**KIRKLEES METROPOLITAN COUNCIL
INVESTMENT & REGENERATION SERVICE**

DELEGATED DECISION TO DETERMINE PLANNING APPLICATIONS

Reference No:	2023/62/91716/W
Site Address:	14a, Mill Moor Road, Meltham, Holmfirth, HD9 5JY
Description:	Erection of porch and alterations to convert garage to habitable room including associated external alterations
Recommending Officer:	Laura Yeadon

HOUSEHOLDER DELEGATED REPORT

client	ROSIE LAVER AND DAVE RICHARDSON		
project	PROPOSED PORCH AND GARAGE CONVERSION 14A MILL MOOR ROAD MELTHAM HD9 5JU		
drawing	PROPOSED PLANS AND ELEVATIONS		
revision	notes	date	drawn
scale :	1:50 & 1:100 AT A1	04.23	PB
project no.	2266	drawing no.	02
		revision

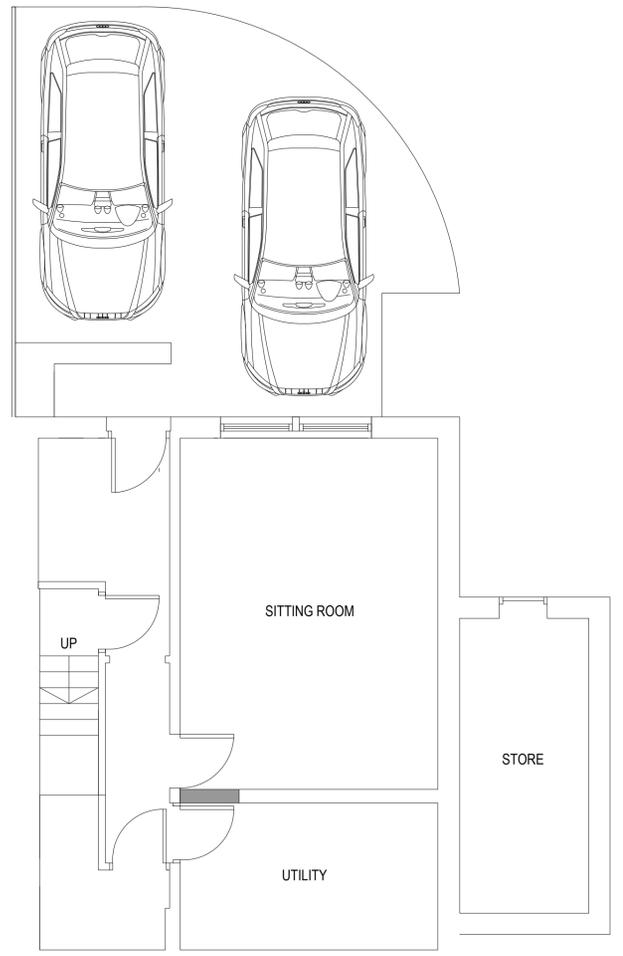
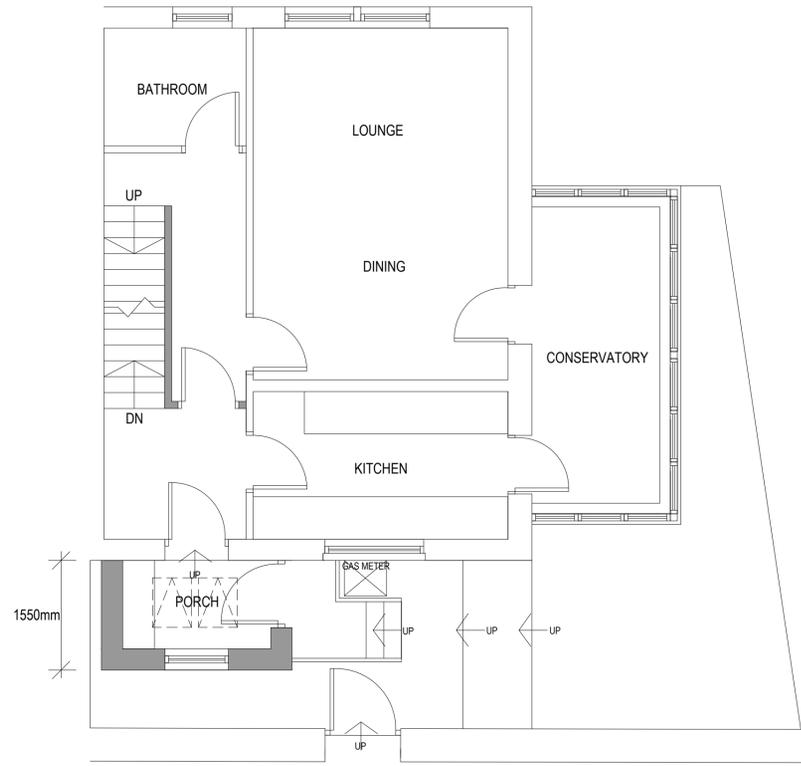
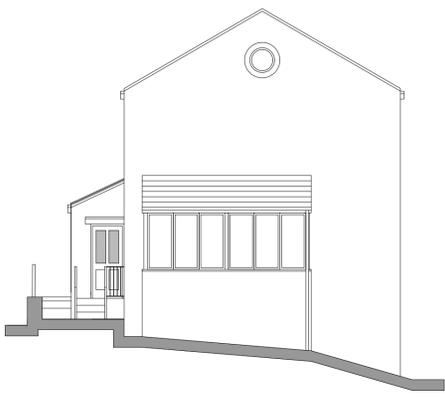
Porch – located adjacent to the shared boundary with the attached neighbouring property projecting from the front elevation by 1.55 metres and being a width of 2.7 metres. The eaves height would be 2.7 metres with the overall height being 3.5 metres. Construction materials would be natural stone for the walls and stone slates for the roof with timber windows and doors.

Single storey front extensions permitted where:	<u>Yes - COMPLY</u>	<u>No - JUSTIFY</u>
The house is set well back from the pavement or is well screened		No – close to the roadside and not screened however not considered intrusive within the street scene
The extension is small, subservient to the original building, well-designed and would not harm the character of the original house or the area	Yes – single storey in height and part-width – would be in keeping the modern style of the property as approved under 2005 application	
The materials and design match the existing features of the original house	Yes – materials to match	
The extension would not unreasonably affect the neighbouring properties	Yes – the porch is located adjacent to the entrance door of the neighbouring property.

It is considered that due to the overall size and scale of the proposed porch which is separated from the listed building by the busy Mill Moor Road, it is not considered that the works would cause harm to the listed buildings therefore the works would be acceptable and compliant with Policy LP35 of the Kirklees Local Plan and advice within Chapter 16 of the NPPF.

Height, scale and massing	<ul style="list-style-type: none"> • KDP 1 and 2 of the SPD • Policy LP24 Design (a), (c) and (d) of the KLP • Chapter 12 of the NPPF 	Single storey and part width, therefore subservient	✓
Facing materials and detailing	<ul style="list-style-type: none"> • KDP 9 of the SPD • Policy LP24 Design (d) (iii) of the KLP • Chapter 12 of the NPPF 	Construction materials to match	✓
Roof style	<ul style="list-style-type: none"> • KDP 1 and 2 of the SPD • Policy LP24 Design (a), (c) and (d) of the KLP • Chapter 12 of the NPPF 	Simple lean-to roof	✓
Window proportions	<ul style="list-style-type: none"> • KDP 1 and 2 of the SPD • Policy LP24 Design (a), (c) and (d) of the KLP • Chapter 12 of the NPPF 	Windows for garage conversion would match those on upper floors in terms of dimensions – openings within the porch are typical of those within a porch construction	✓
Accessibility for all users	<ul style="list-style-type: none"> • KDP 17 of the SPD • Policy LP24 Design (f) • Chapter 12 of the NPPF 	Access to the property would be via the proposed porch within the internal door retained in the same location as existing

- 14 Mill Moor Road – attached neighbour – porch has a limited projection of 1.55 metres close to the shared boundary where the neighbouring door is located – 45 degree line from window opening would not be cut

3. The external walls and roofing materials of the extension and the walling to the garage conversion hereby approved shall in all respects match those used in the construction of the existing building and be retained thereafter.
